Ribble Valley Borough Council
Council Offices
Church Walk,
Clitheroe
Lancashire
BB7 2RA

Phone: 0300 123 6780
Email: Kathryn.Walsh@lancashire.gov.uk
Your ref: 3/2025/0144
Our ref: 3/2025/0144/HDC/KW
Date: 24 April 2025

Location: Tan Yard Farm Ribchester Road Hothersall PR3 3YA
Proposal: Proposed extension and remodelling (with associated building works) to the existing barn, to create a detached dwelling (previously subject to approval 3/2023/0075). The erection of a detached double garage with habitable living space above, as an annexe to that family dwelling, and external works and change of use of land to residential curtilage.
Grid Ref: 362555 436532

# DETACHED GARAGE WITH ROOM-IN-ROOF: PROPOSED FLOOR PLANS AND ELEVATIONS

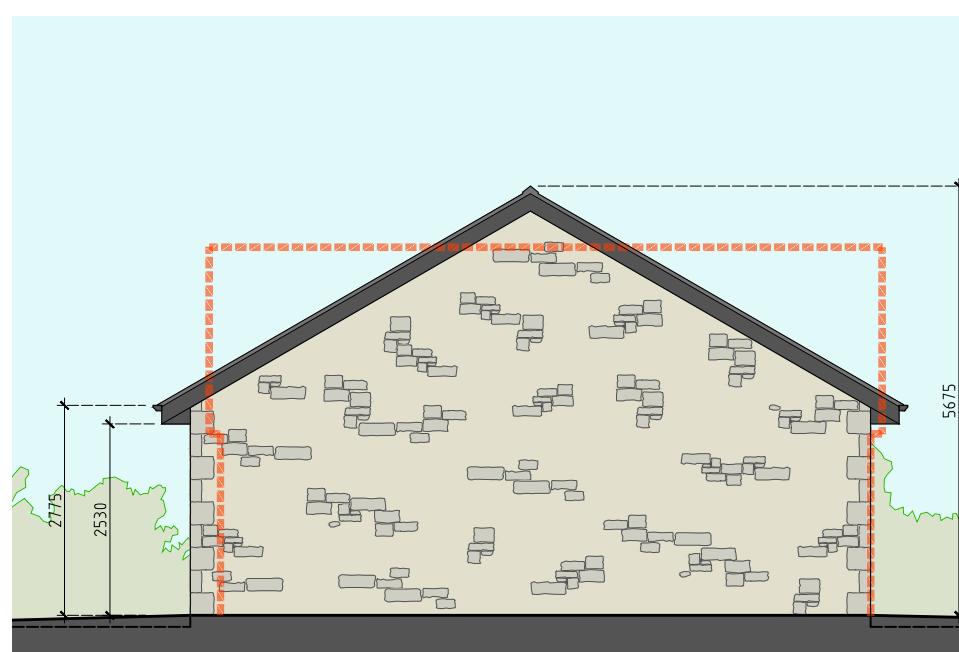
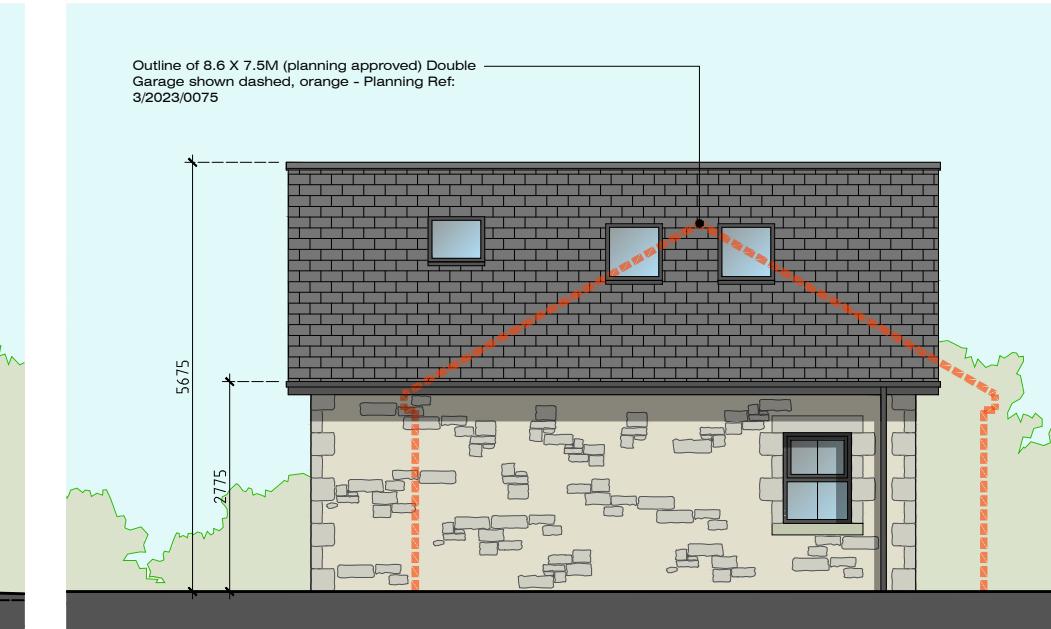
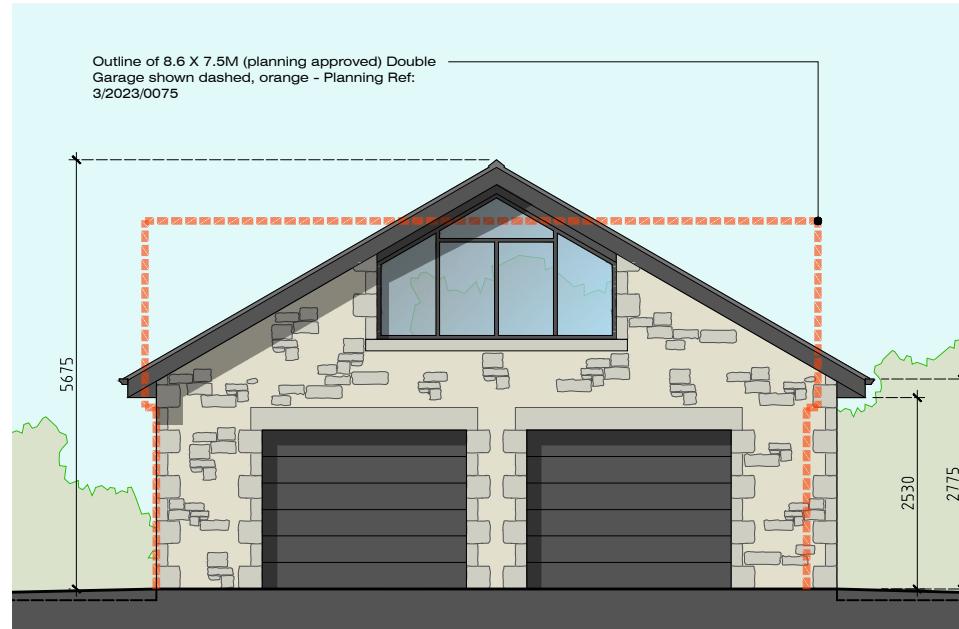
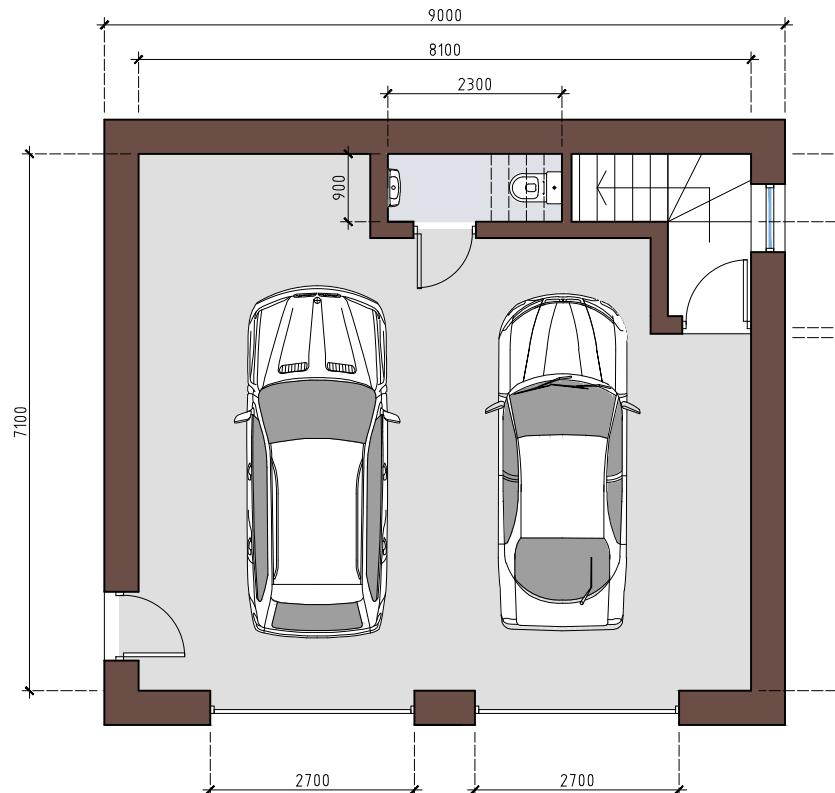
The LHA have reviewed drawing number 2264-P01, Revision B and JM-0316 007, Revision A and are aware that the car parking provisions are similar to the previously approved applications. Whilst the development of the garage results in a slightly smaller internal layout, the site can still retain acceptable off-street parking provisions as well as ensure ingress and egress in a forward gear.

1. The development hereby permitted shall not be occupied until the car parking area has been surfaced or paved in accordance with a scheme to be approved by the Local Planning Authority. The car parking area shall thereafter be kept free of obstruction and available for the parking cars at all times.

2. The garage(s)/parking areas hereby approved shall be kept available for the parking of vehicles ancillary to the enjoyment of the household(s) and shall not be used for any use that would preclude the ability of their use for the parking of private motor vehicles, whether or not permitted by the provisions of the Town and Country Planning (General Permitted Development) Order 2015 or any order amending or revoking and re-enacting that order.

3. The detached building hereby approved shall only be used ancillary to the enjoyment of the household of Barn 3 and shall not be used by way of sale or sub-letting to form separate residential accommodation.
